Re: Long Plat 22-00005 "Suncadia Phase 2 Division 8"

Before the CDS Staff recommend to the commissioners to approve this latest development from "Suncadia Resort LLC" please consider and fully address these issues:

SUNCADIA RESORT LLC  
**PHASE 2 DIVISION 8**  
 CONCEPTUAL UTILITY PLAN  
 KITTITAS COUNTY WASHINGTON

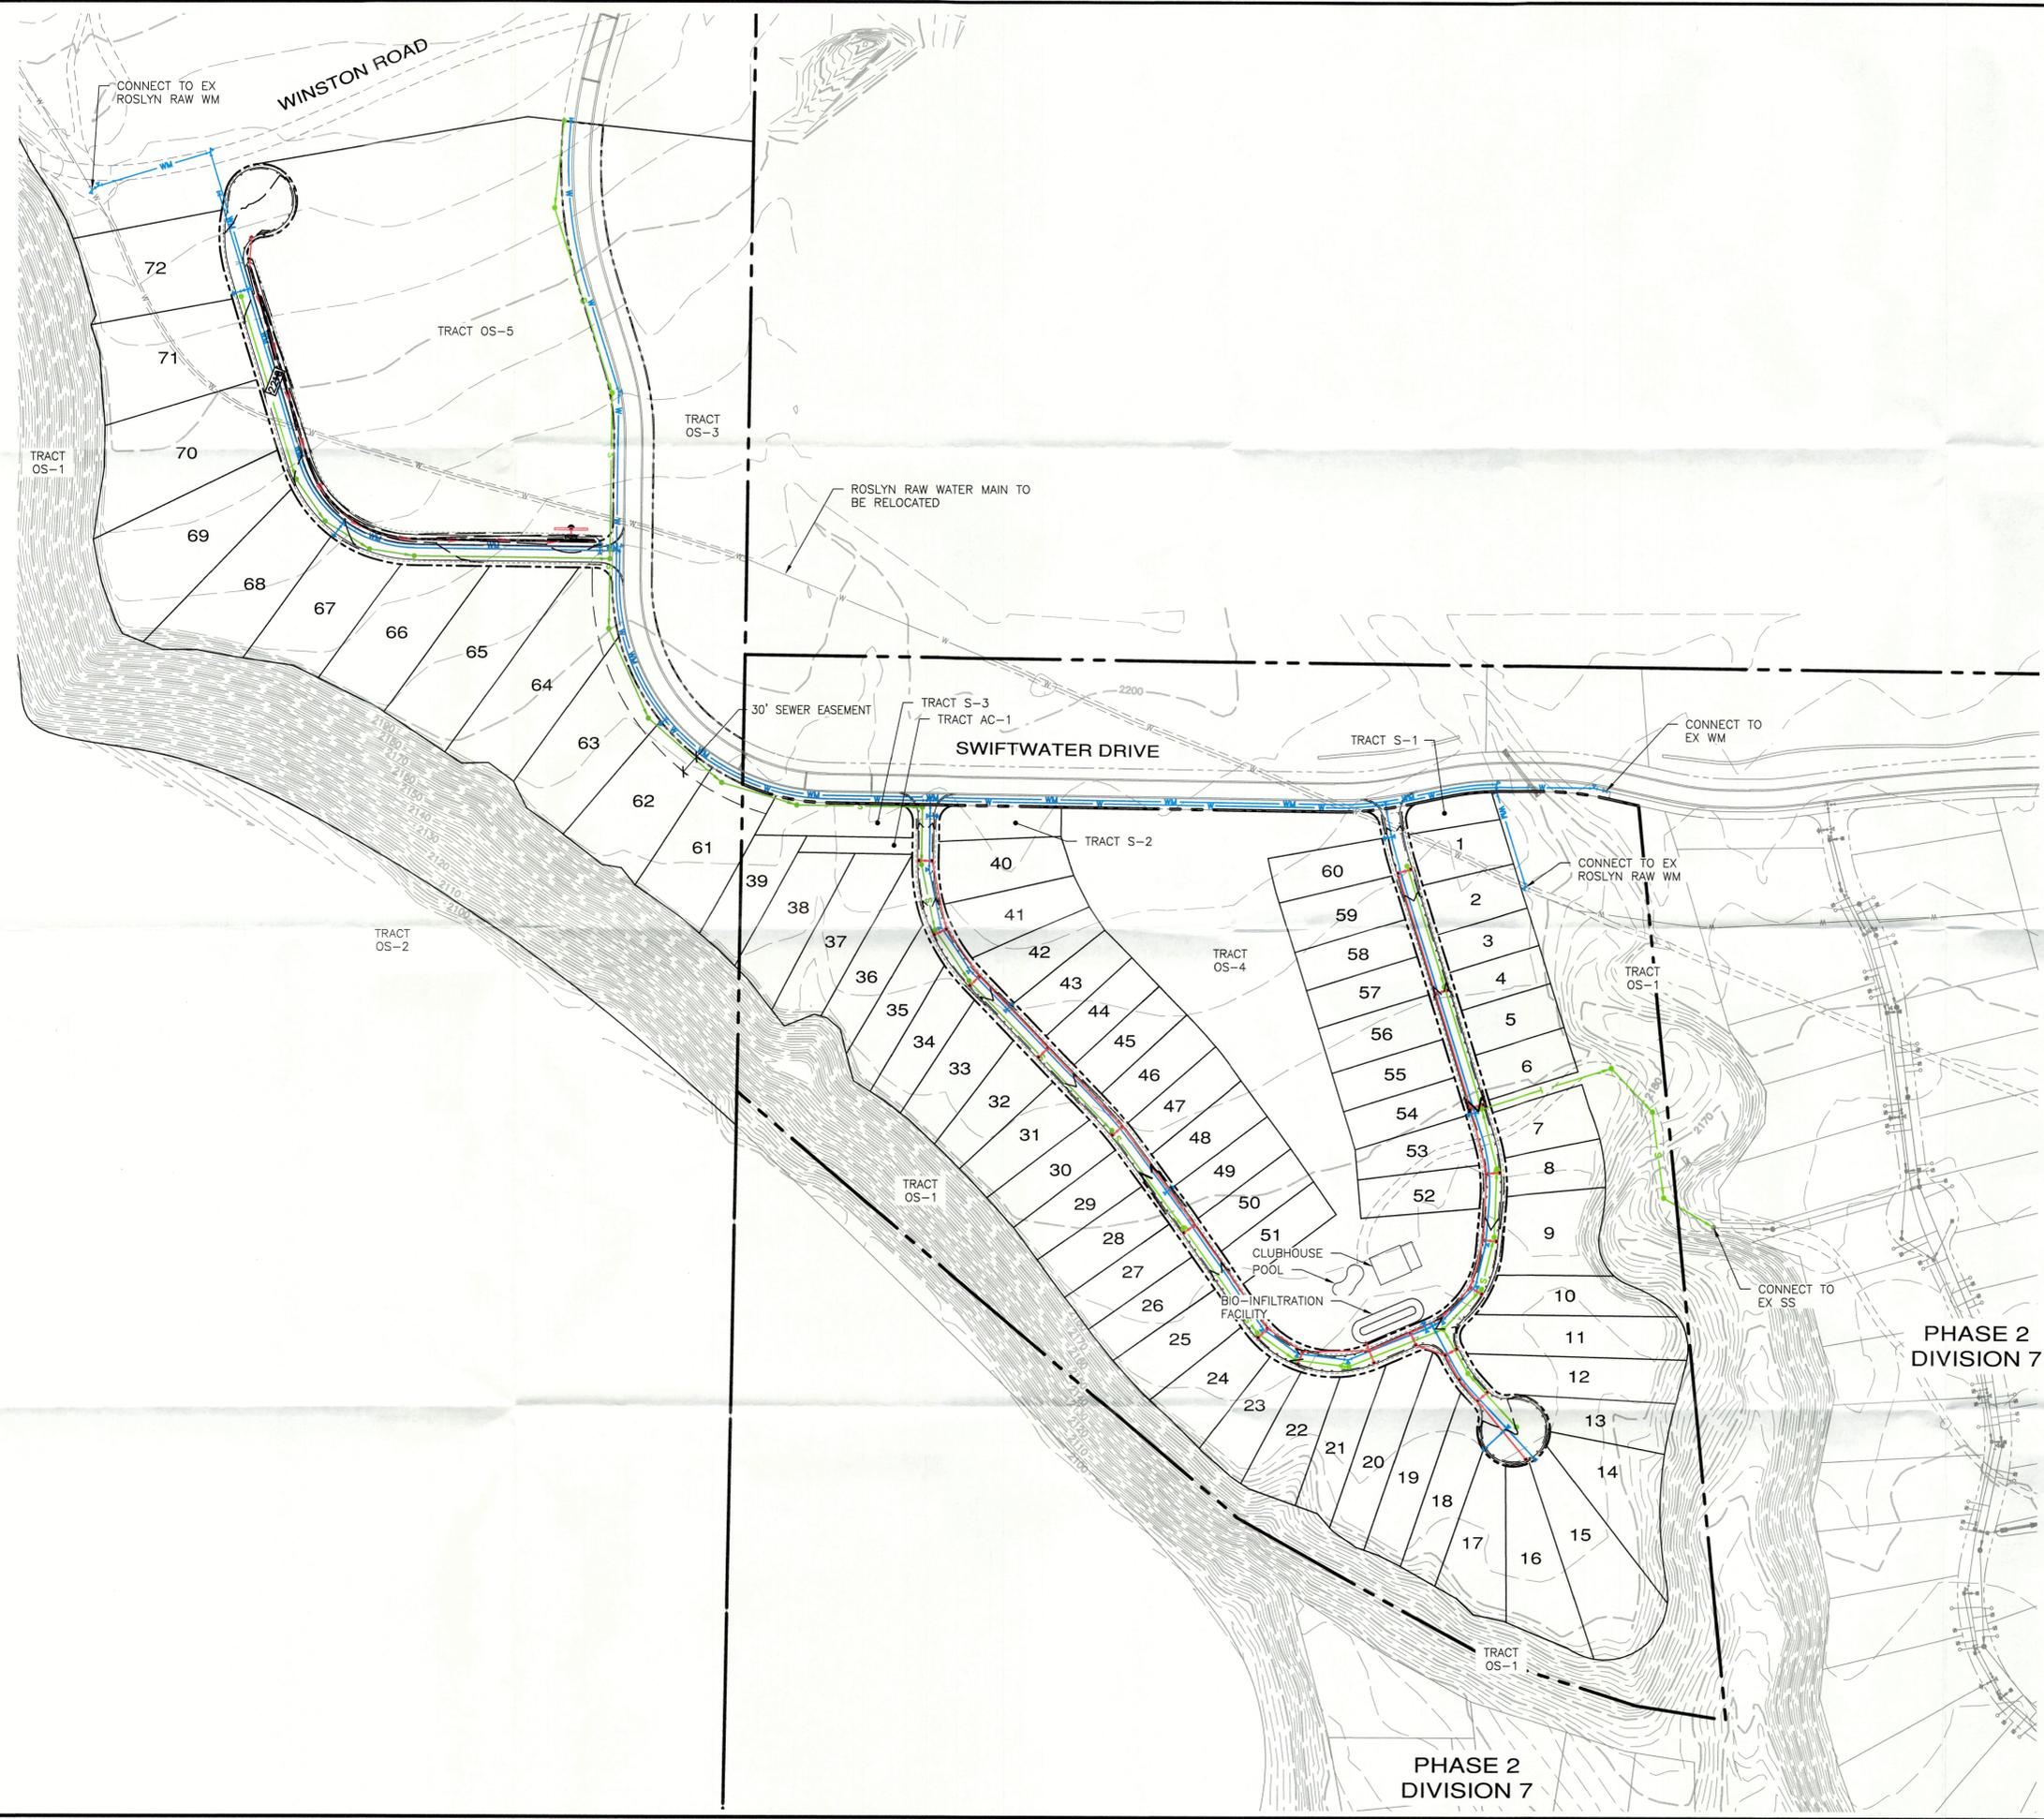
3. SEPA Checklist Attachment 13.b indicates the developer will remove the historic water line (KT02147) which is part of the Roslyn Water system without any regard to its possible historic significance. According to the February 24, 2022 letter from the Washington Department of Archaeology & Historic Preservation to Kelly Bacon, Planner 1, KCCDS, "It should be determined whether the segment of the Roslyn Waterline Complex (KT02147) that passes

through the proposed project area is eligible for listing in the National Register of Historic Places. If this site is determined eligible, a permit from DAHP will be required in order to work within its boundary.” While the letter was in reference to a previous development in Suncadia, the same historic water line traverses this development. Has CDS and/or the property owner (Suncadia) determined the historic significance of this water line per the letter? Would it not be prudent to investigate this before it is permanently destroyed?
